# Cumberland Council

30 August 2016

## Forensic Pathology and Coroner's Court, Lidcombe (SSD7545) Notice of Exhibition

Reference is made to the above State significant development application for the Forensic Pathology and Coroner's Court, located at 1, 2 and 3 DP 850697, Weeroona Road, Lidcombe. Please find below Council's comments in respect of the proposal.

EXTERNAL SIGNAGE PLAN

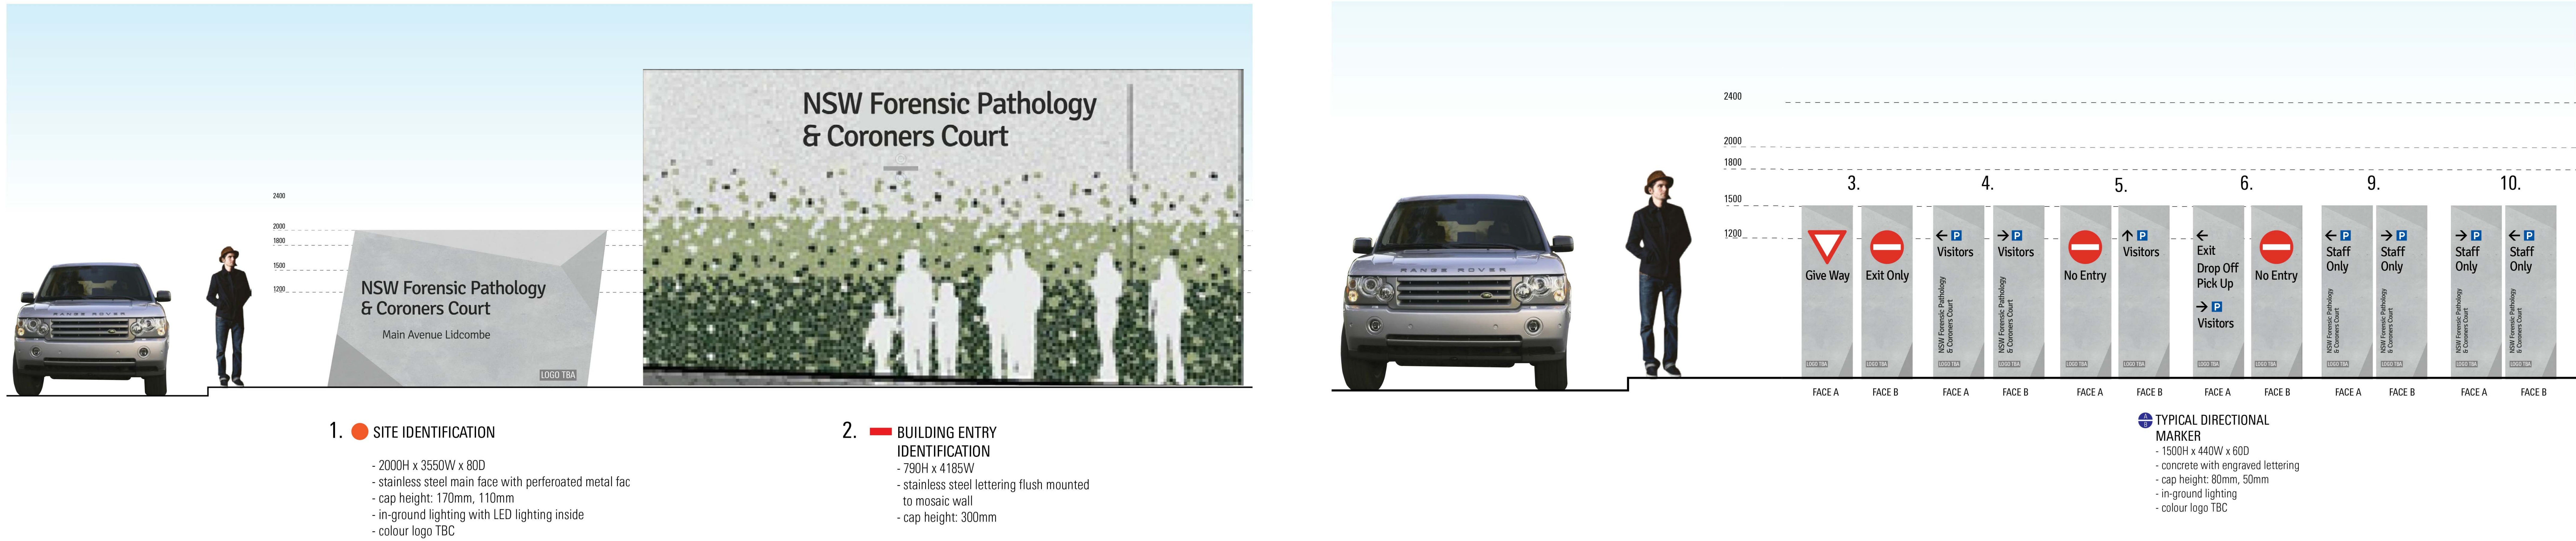
As discussed previously, the landscaped area on the southern side of Main Avenue is a dedicated public reserve owned by Council. It is noted that sign no. 3, as shown on the plan titled "Schematic Sign Location Plan – External Signs Only" Issue B prepared by Minale Tattersfield and dated 13 July 2016, is proposed to be located on the public reserve owned by Council. As such owner's consent is required for the proposed placement of any signage on this site. Alternatively, the signage can be located within the subject development site.
